Re: Beevor Court, Barnsley

Further to our recent telephone conversation, please find below details of the proposed changes to the acoustic specification. This letter can be passed on to Sarah Newman in Environmental Health and Keiron Dunn in Planning to seek agreement to the change to the planning condition.

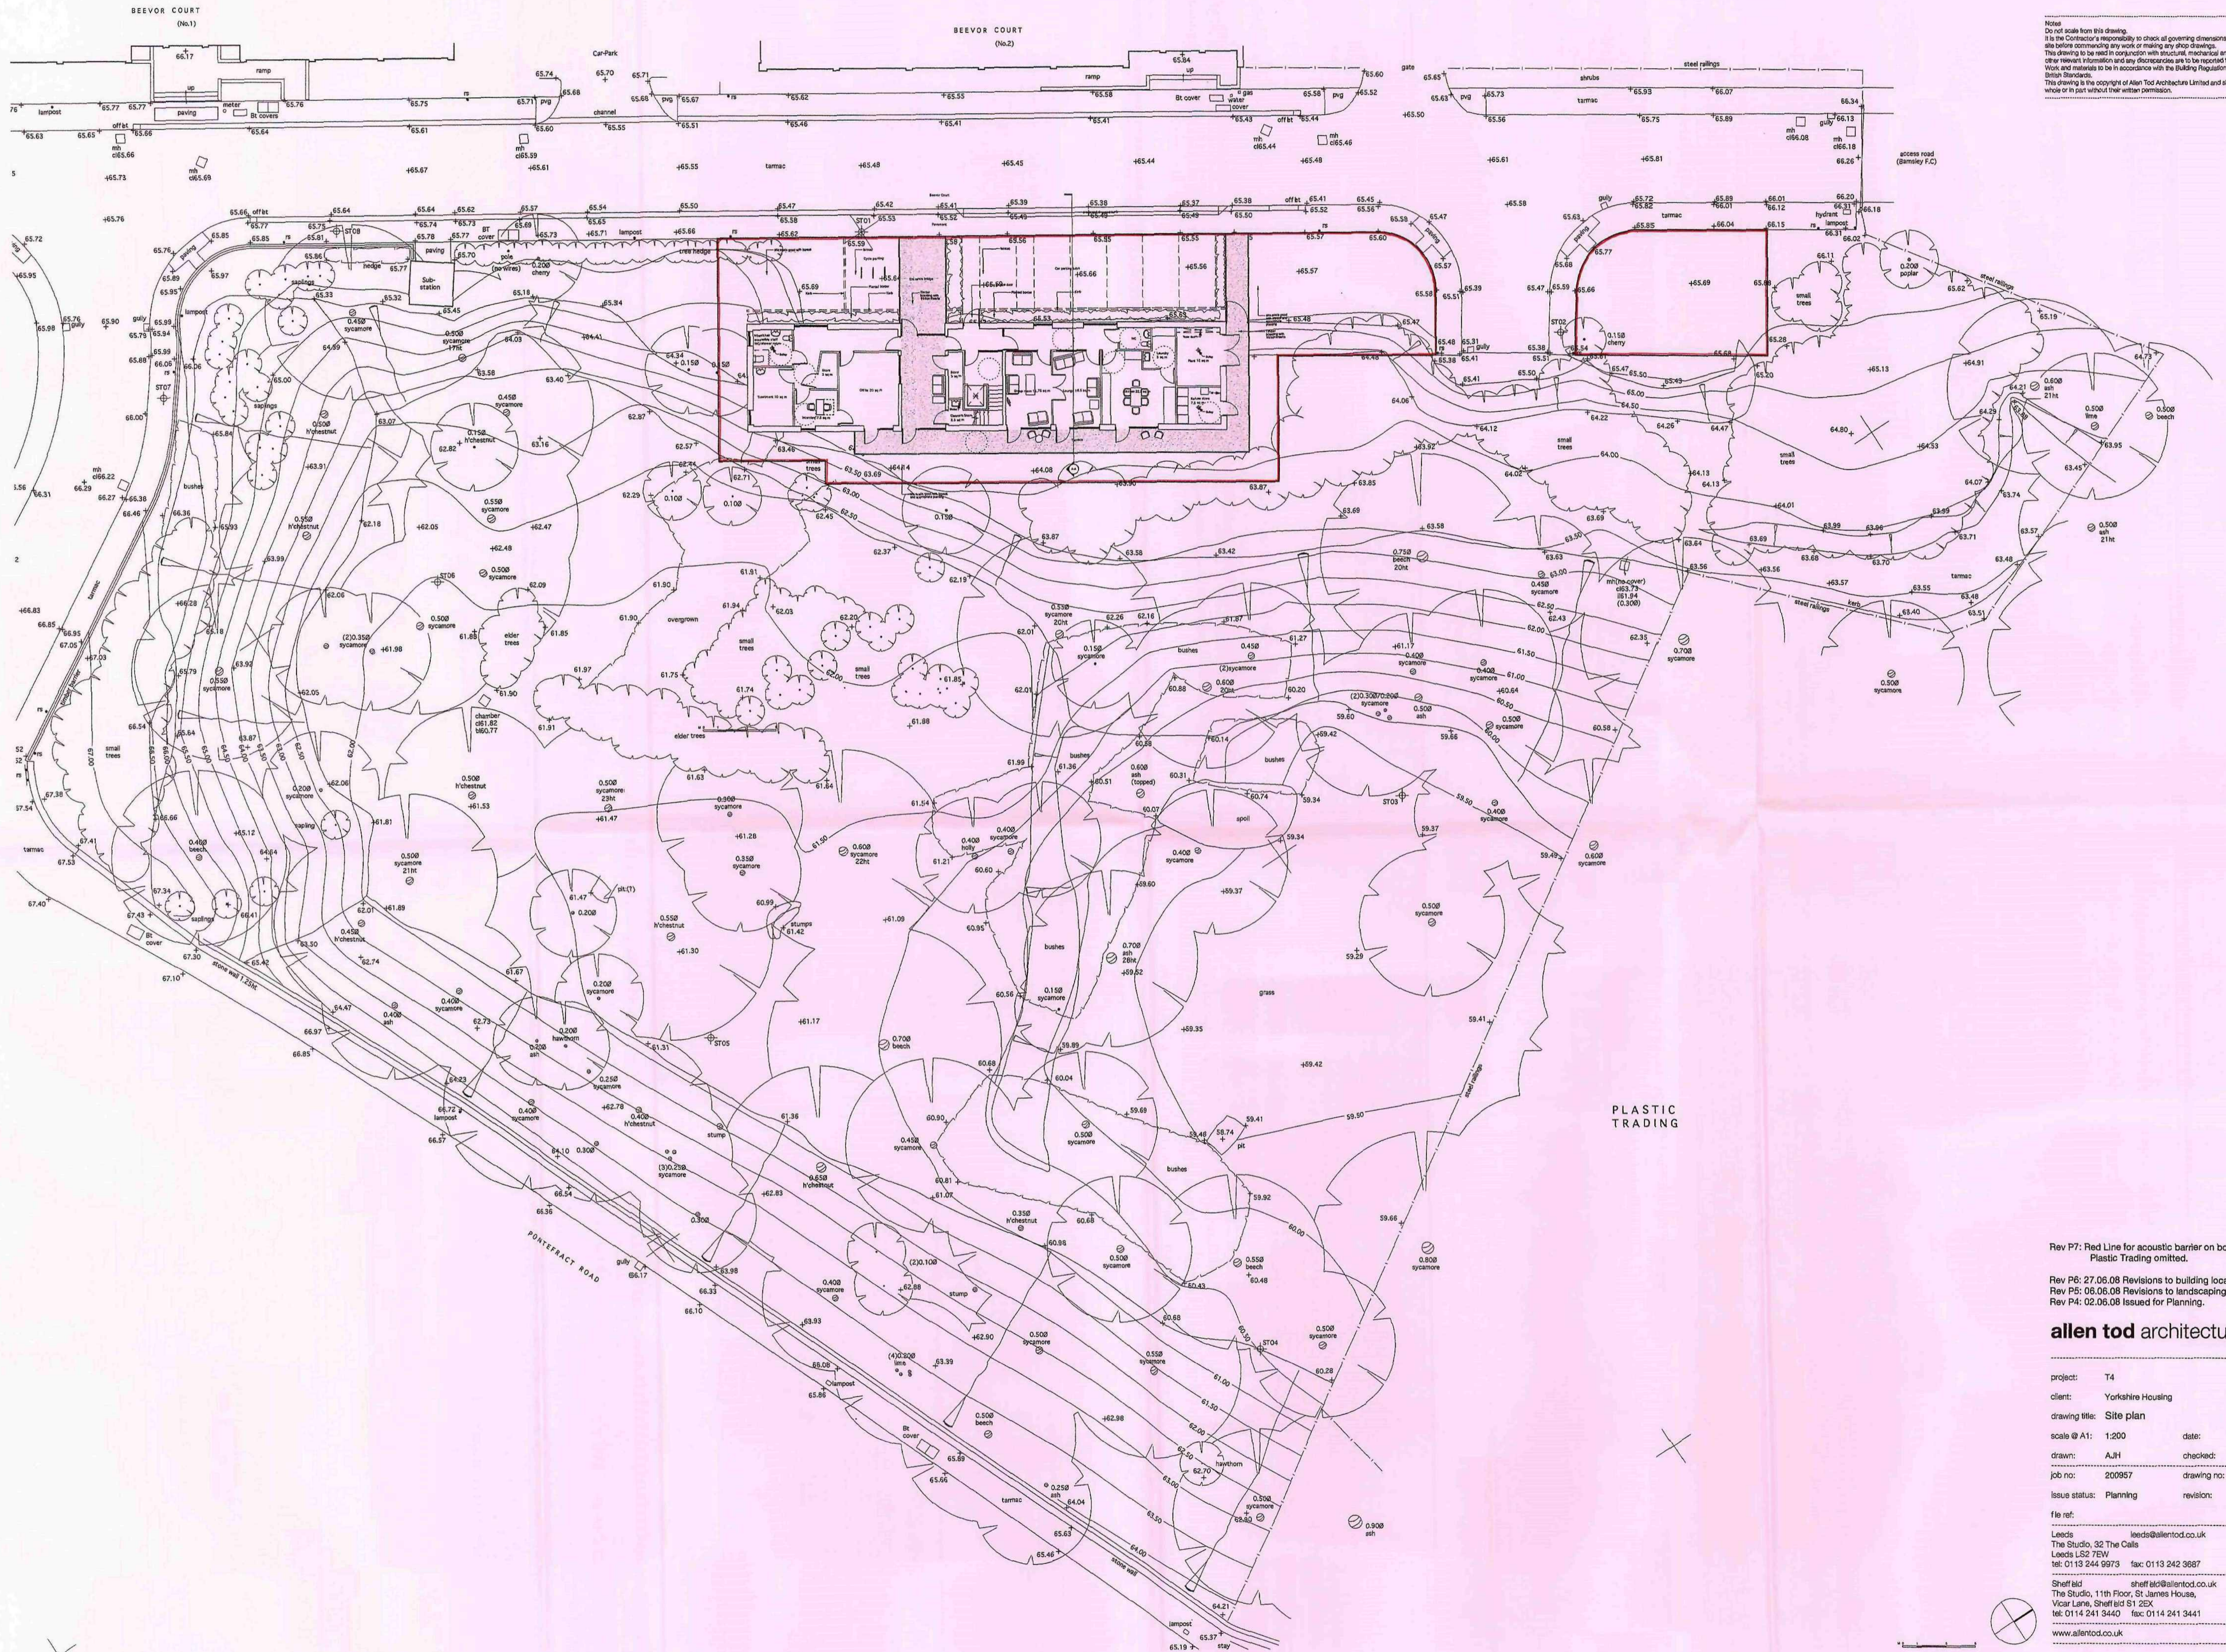
I have spoken to Sarah Newman and she indicated that she is willing to consider the omission of the acoustic fence if the building envelope specification is enhanced.

An increased glazing and ventilation specification to the bedrooms on elevations where there is a line of sight to the industrial premises is given below.
